Road Safety Audit Stage 1

**Waterloo Square, Bognor Regis – Alternative
Norfolk Street Access**

Road Safety Answers reference no: RSA328

Project Title:	Date:
Waterloo Square, Bognor Regis	06.10.2020
Document Title:	Drawn by / Checked by:
Proposed Site Layout Plan	SR / GG
Drawing Scale / Sheet Size:	Client:
1:500 @ A3	B5 ltd
Drawing Status:	Drawing Number / Revision:
PLANNING	18.103.400

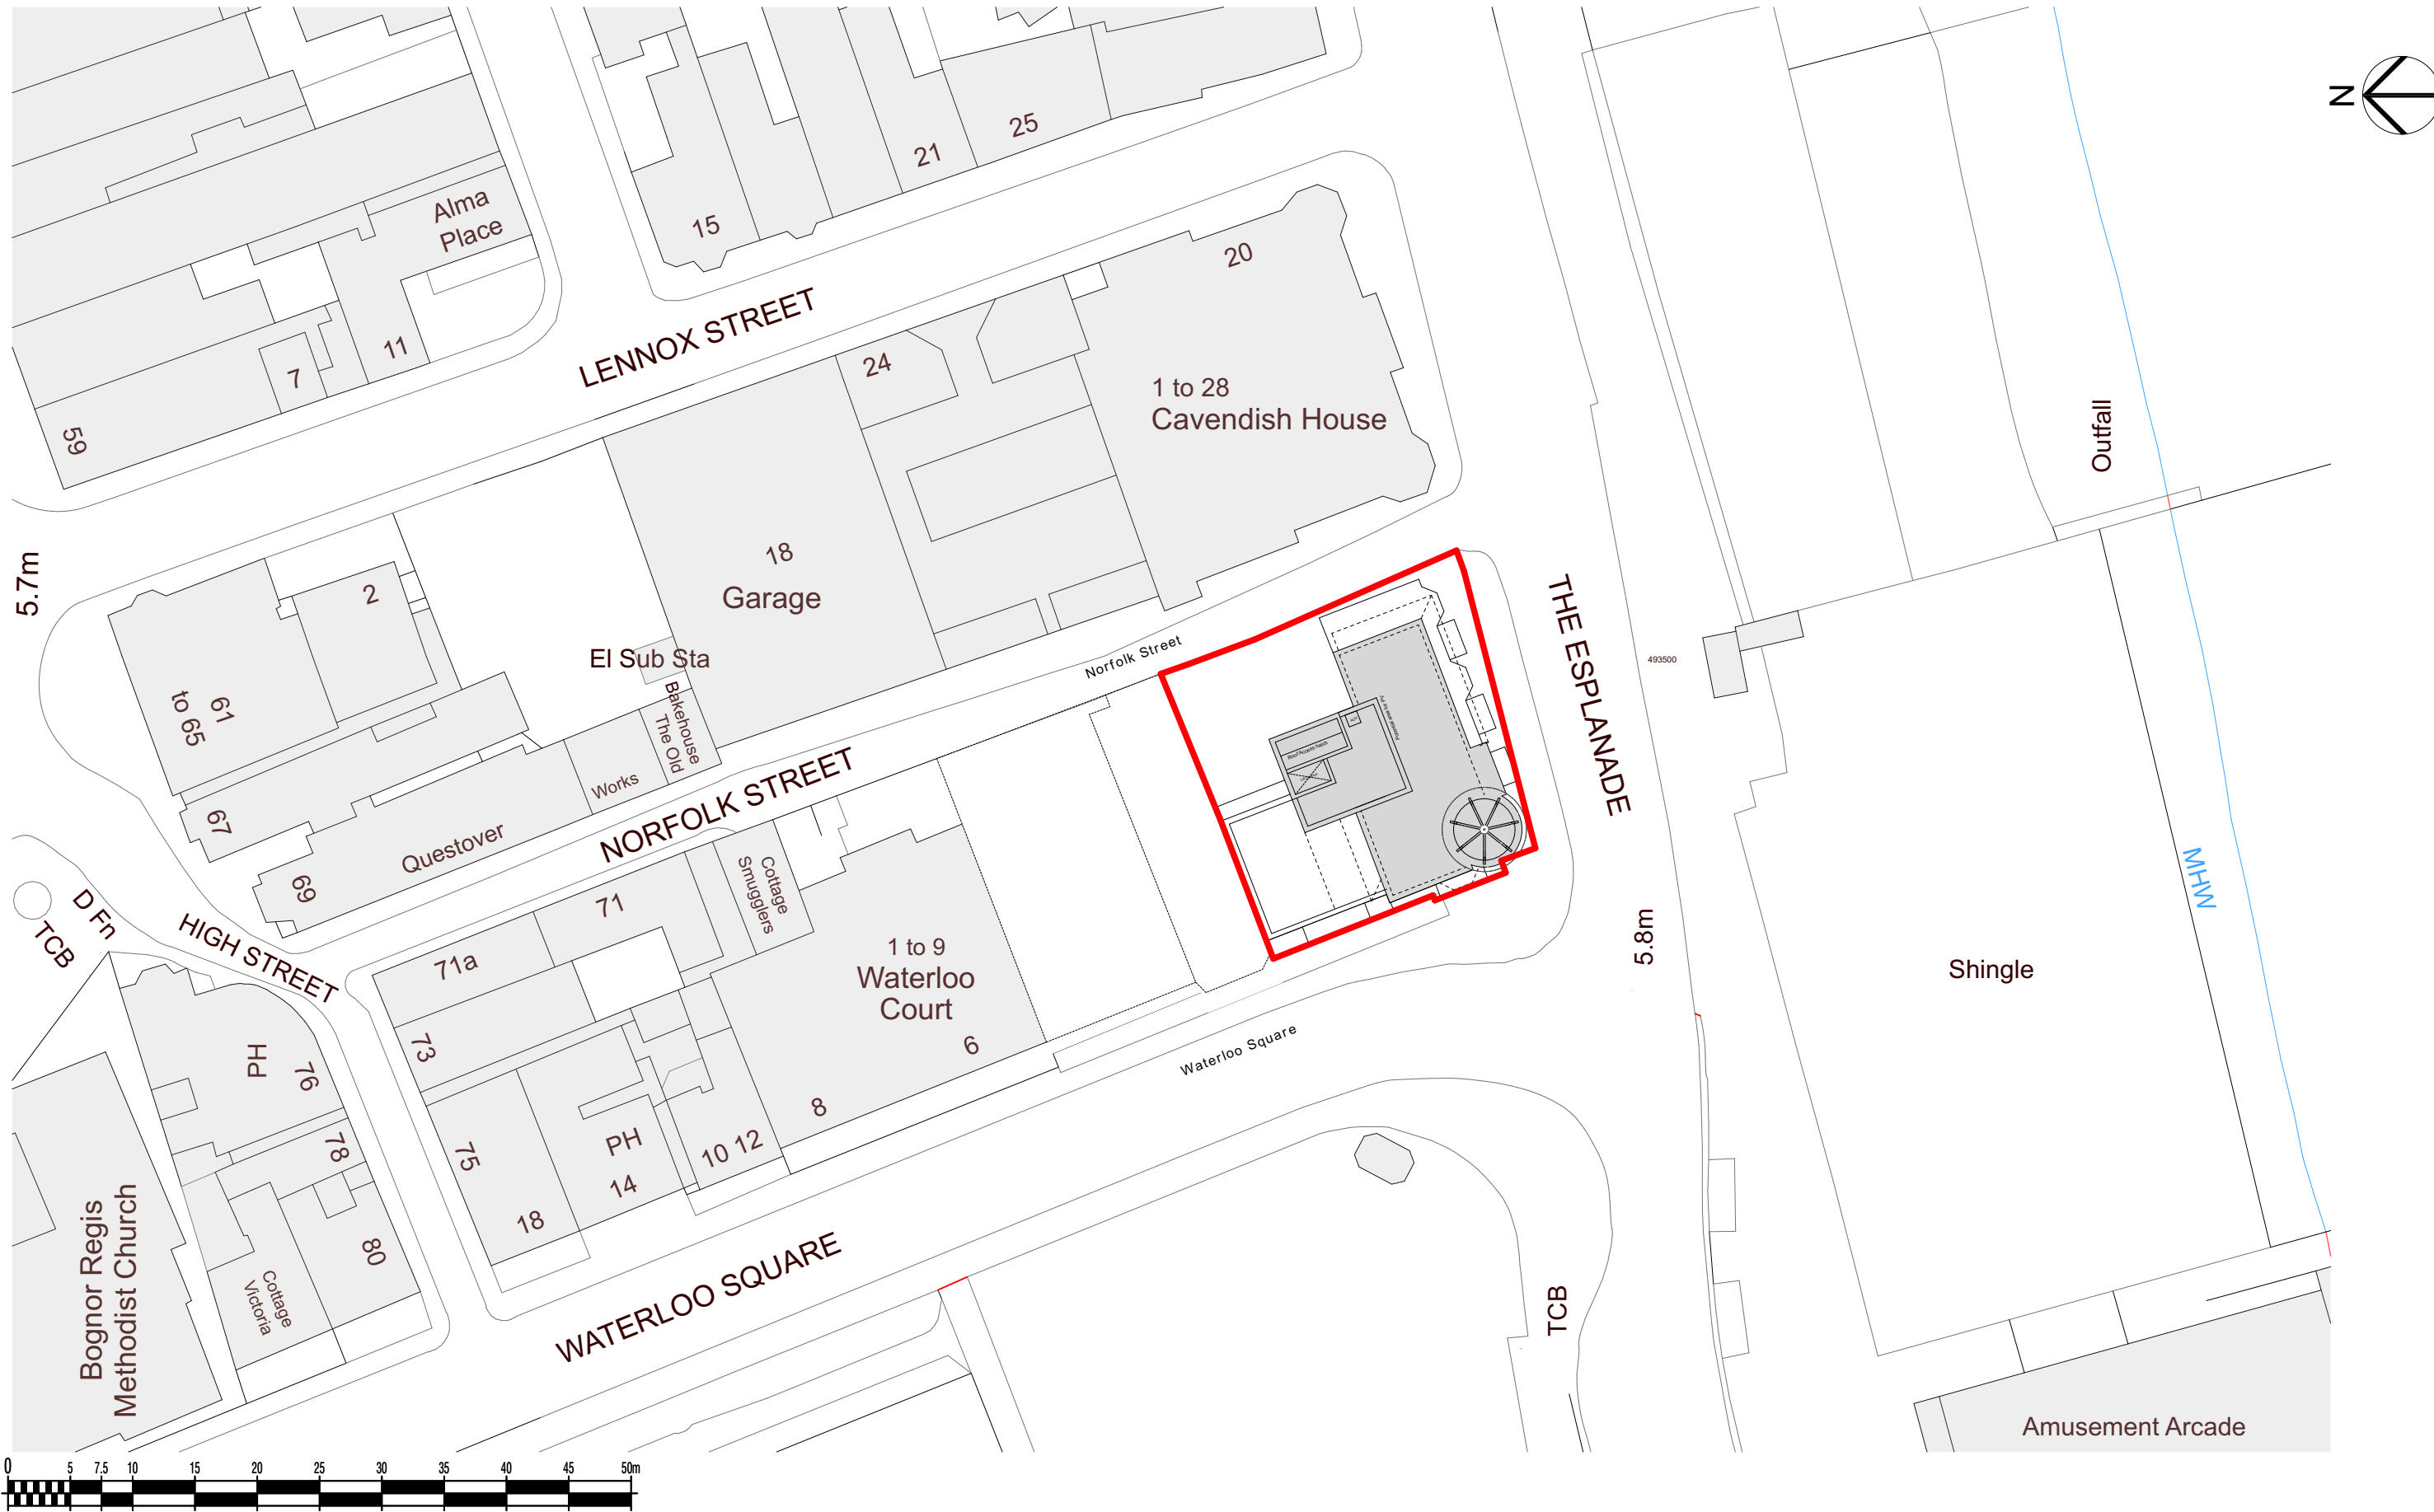
Location: A – Northern end of the development access onto Norfolk Street.

Summary: Risk of side swipe collisions.

The drawing does not indicate whether there will be a boundary treatment on the northern boundary on the site e.g. a wall or fence, between this development and the currently derelict site to the north. If the boundary treatment is low i.e. less than 1.05m in height, drivers exiting the proposed parking bays will be able to see over it, minimising the conflicts with vehicles approaching from the north on this one-way street. If the boundary treatment is too high, the visibility will be obscured, and the risk of a side impact increases, albeit slightly (vehicle speeds in this narrow street are low, and the parking spaces are for staff – trips to and from them will, therefore, be infrequent).

Any boundary treatment along the northern edge of the development should be kept below 1.05m.

Agreed

The designer has proposed no boundary treatment in this location.
